From: Alys Lewis [REDACTED]
Sent: 24 November 2020 09:31
To: Amber Willard <Amber.Willard@arun.gov.uk>
Subject: Reference No.FP/197/20/HH Proposed Development at 15 Blake's Road, Bognor Regis PO22 7EE

We write as immediate neighbours, at 2 Culver Road (to the north of the above property), to object to the proposed alterations and extensions. We believe they would be detrimental to the enjoyment of our amenity as follows:

PROPOSED LOFT CONVERSION

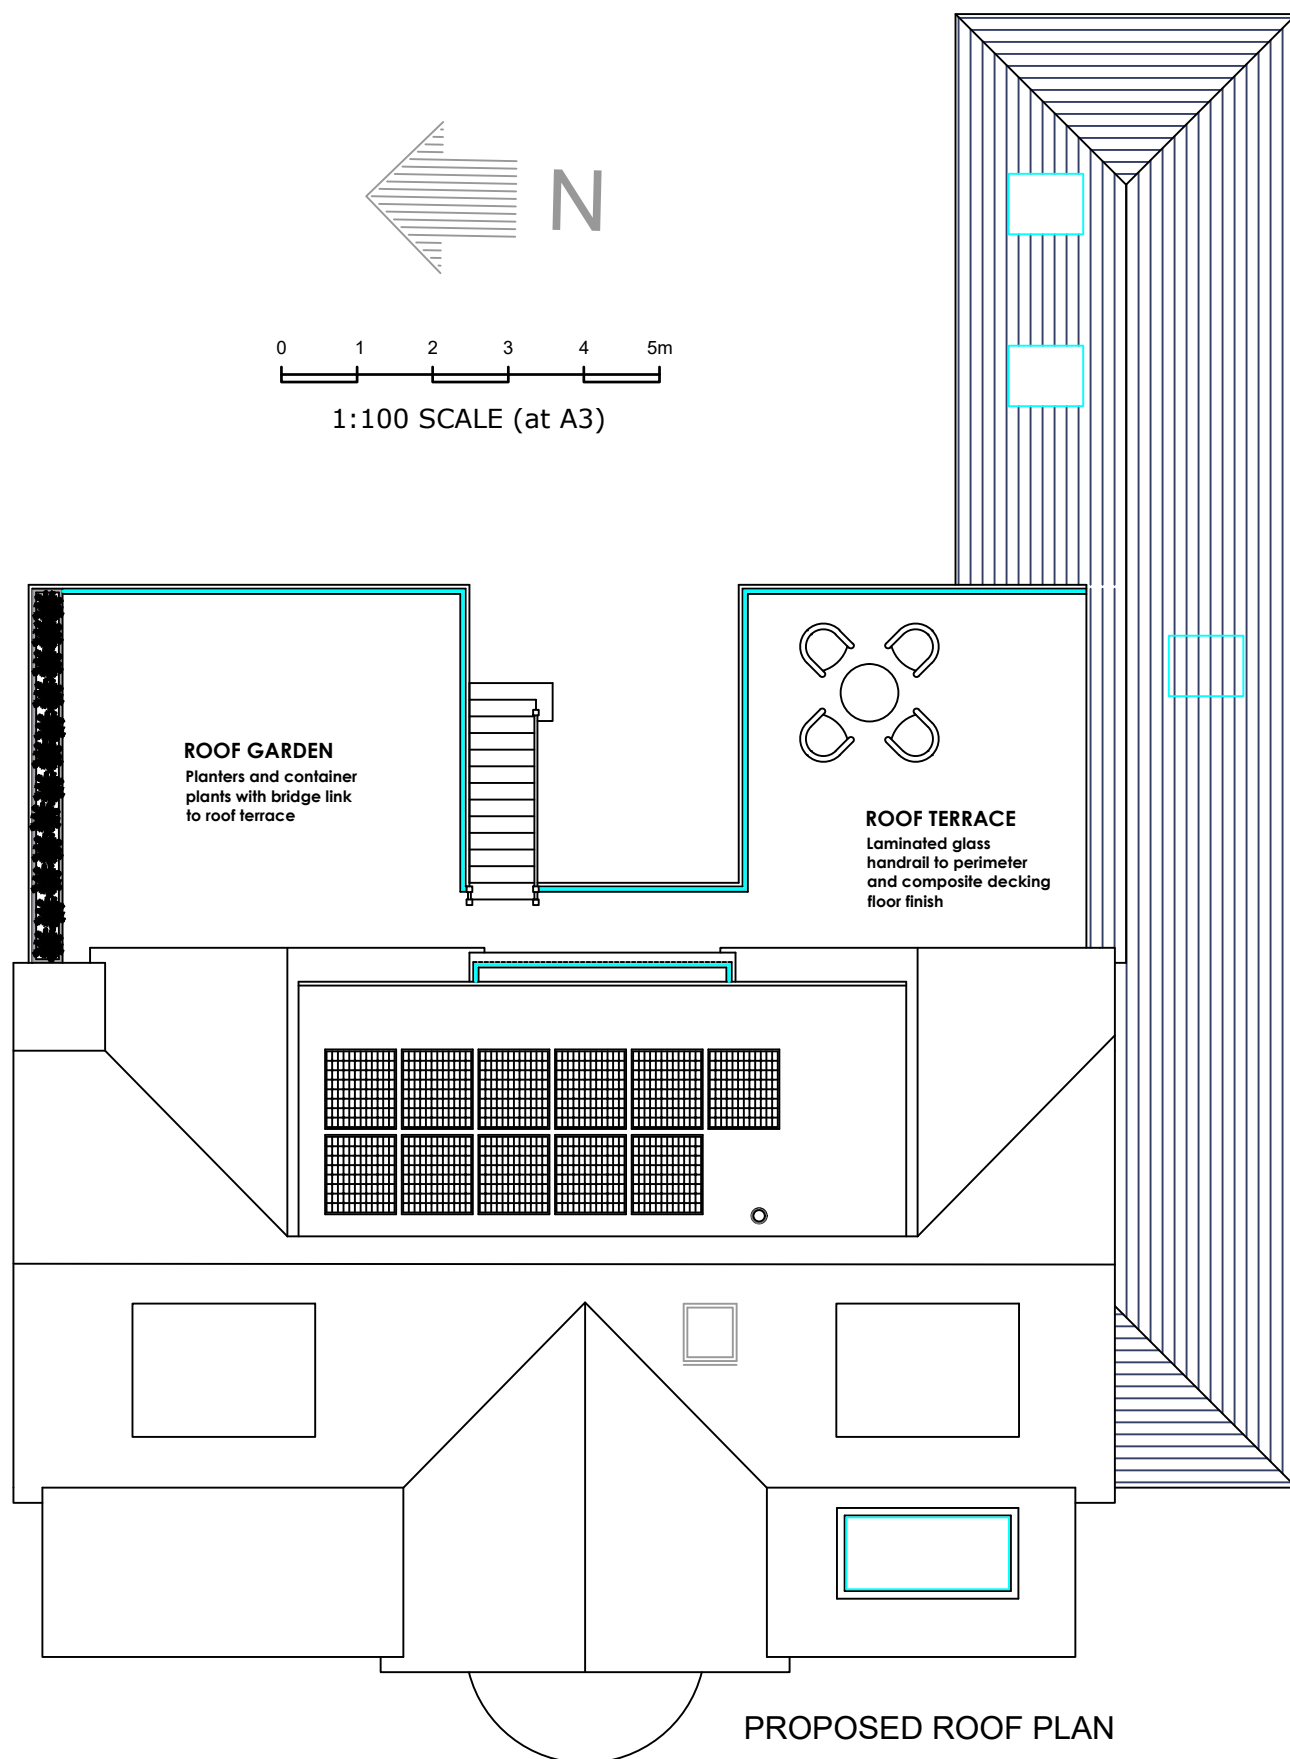
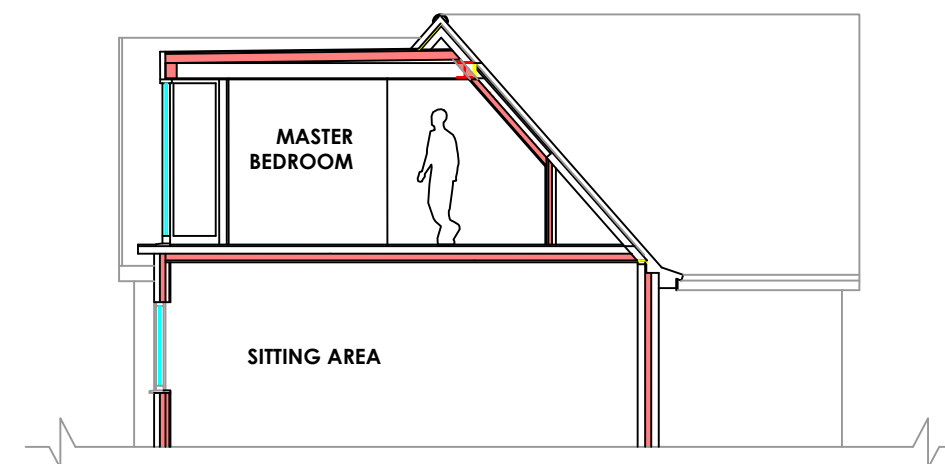
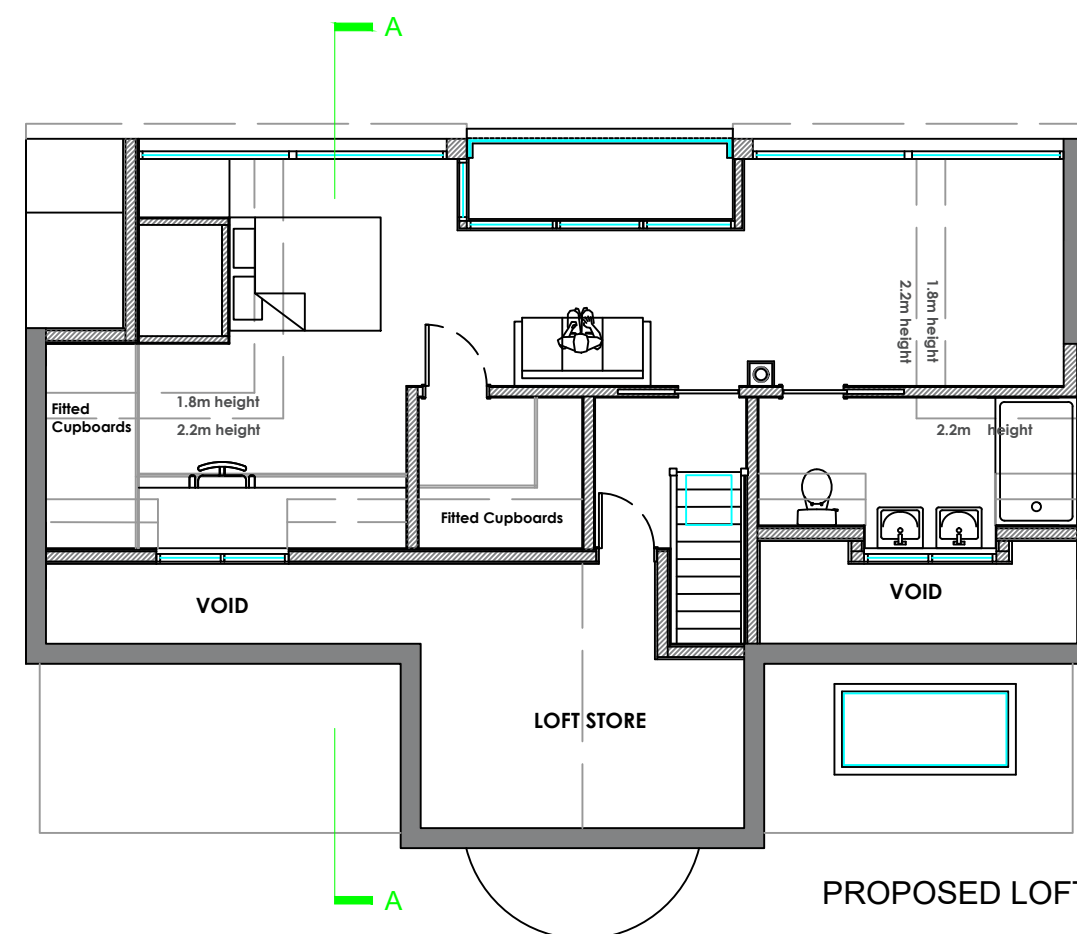
The proposal includes the raising of the main pitched roof and alteration/extension of the flank walls close to the boundary of our property. The changes would be overbearing and affect the outlook from our existing rear living room windows and garden area (see attached photographs). This would be particularly evident because number 15 is due south of us and would cut out sunlight, especially in the winter months when the sun is lower in the sky.
